16 December 2022 – Deadline 4

Application by Sunnica Ltd for an Order Granting Development Consent for the Sunnica Energy Farm Project

Review of Outline Landscape and Ecology Management Plan [REP3-011] and [REP3-012]

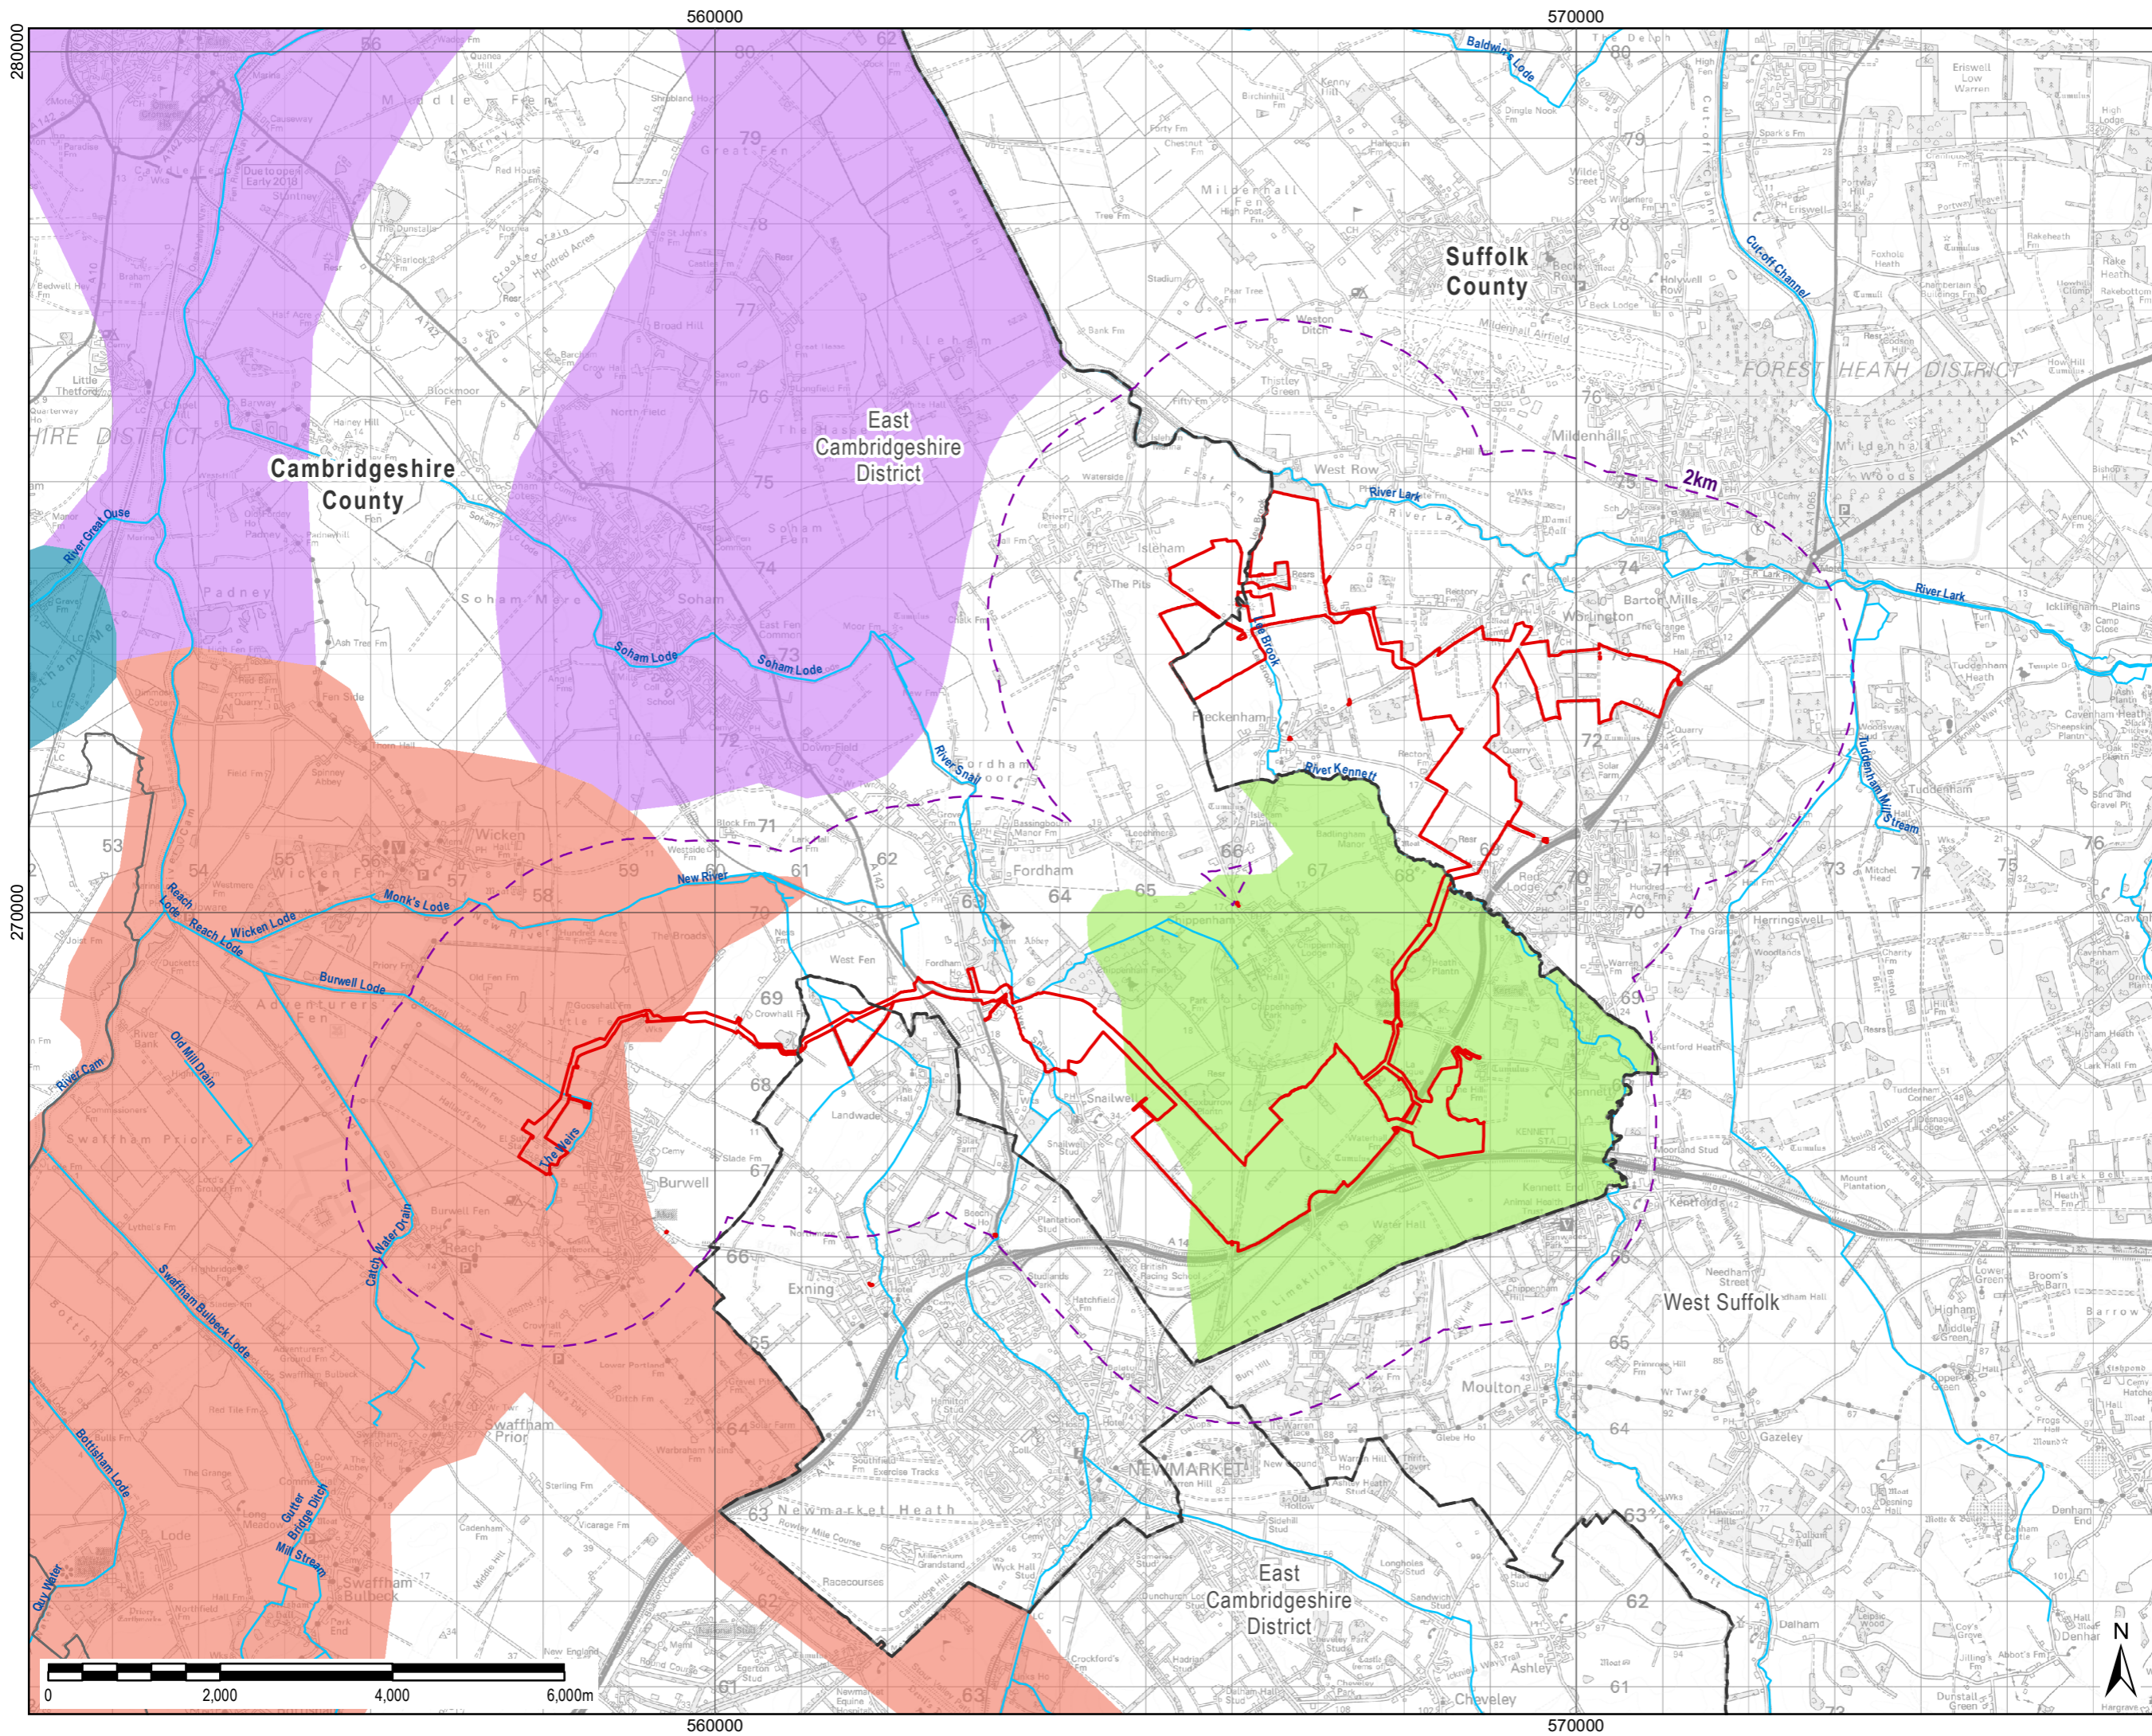
Item	Comment
Figures 1-6 in Annex A	Please show how LEMP relates to wider Nature Recovery schemes and Green Infrastructure Strategies; show improvements to connectivity of habitats

1.6.15	<ul style="list-style-type: none"> - Has the connectivity of the exiting GI network been assessed? - How do the proposed enhancements measures relate to and enhance the GI network and aid NRN? - How are watercourses and ditches being enhanced? And where are the measures outlined?
